Application for a non-material amendment following a grant of planning permission.  
Town and Country Planning Act 1990

APPLICATION REFERENCE:21/505676/FULL

PROPOSAL: Installation of a 5 bay modular building for nursery day care consisting of open plan activity space, storage, room, single office/kitchen area, WC's, together with associated ground works.

## 8. Non-Material Amendment(s) Sought

PROPOSED MODULAR BUILDING Layout Option F

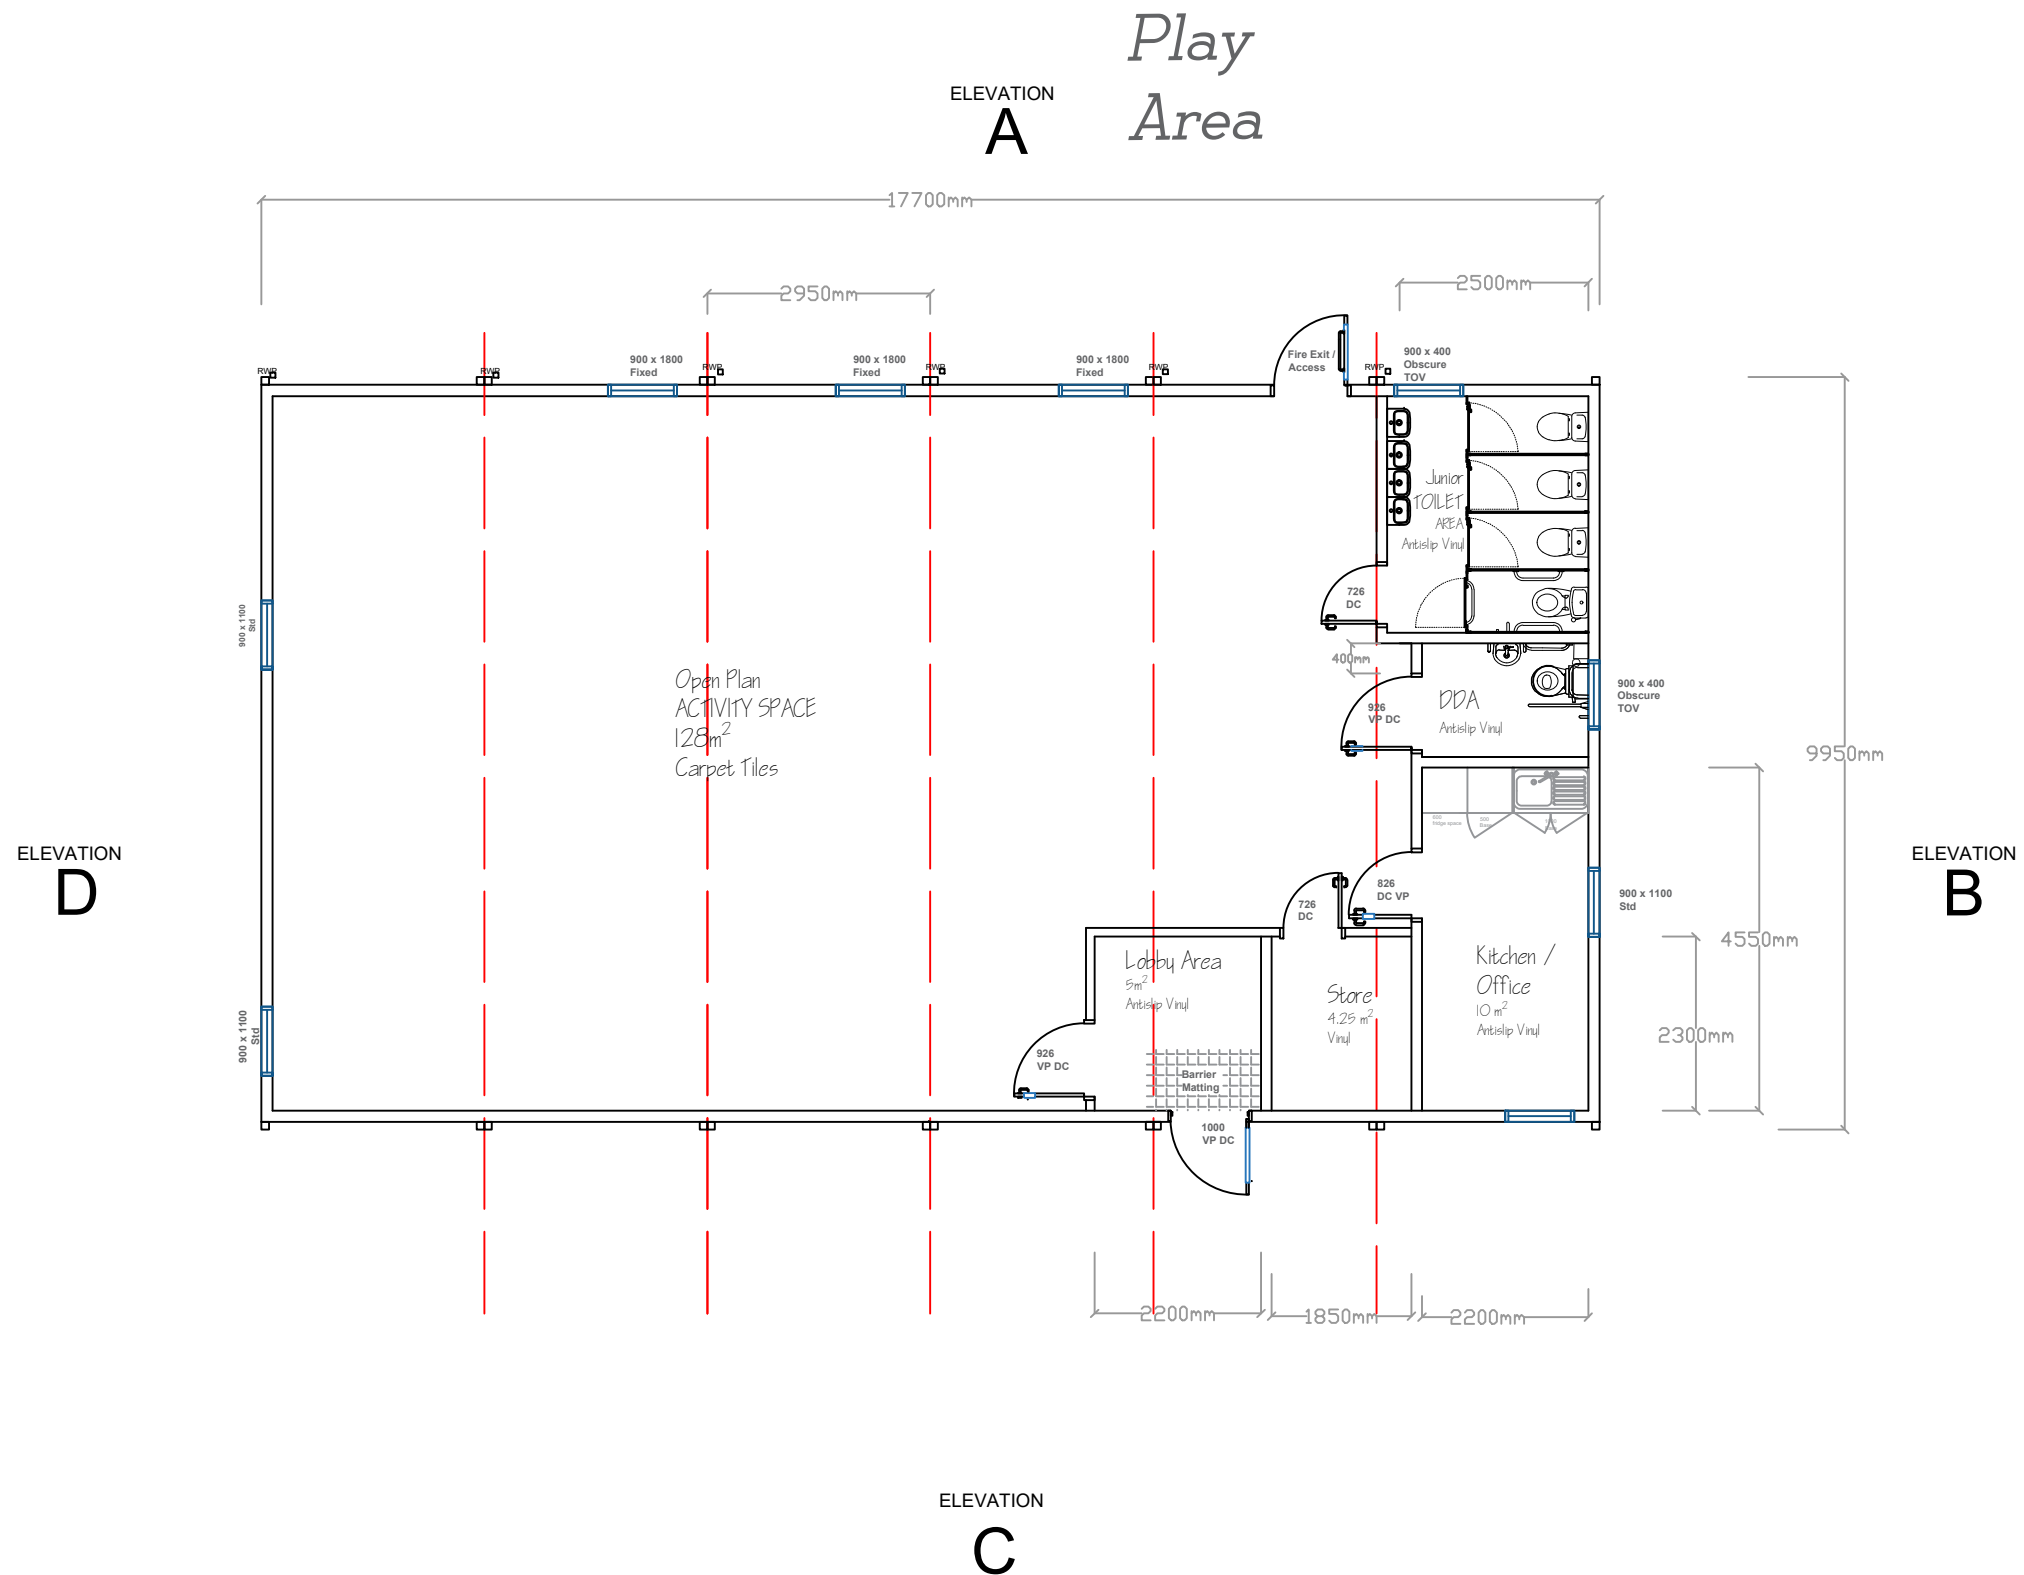
THE BUILDING WE ARE LOOKING TO SUPPLY IS 10M X 3M -6 MODULES EQUALING 180SQM IN TOTAL, WHICH HAS THE SAME SQM AS THE ORIGINAL PROPOSAL OF 5 MODULES.EQUALING 180SQM

FLOOR PLAN  
BUILDING HEIGHT  
BUILDING COLOUR,  
DOOR AND WINDOW LOCATION AND COLOUR,  
SITE LOCATION  
SITE POSITION

THE ORIGINAL 5 MODULAR BUILDING WAS SUITABLE AND THEREFORE WE ARE PROPOSING A 6 BAY MODULAR BUILDING WITH THE SAME 180SQM, LAY OUT AND DETAIL

NO. FLOOR PLAN NO. 10514 REV F 01  
10514 F 01 PROPOSED BLOCK PLAN
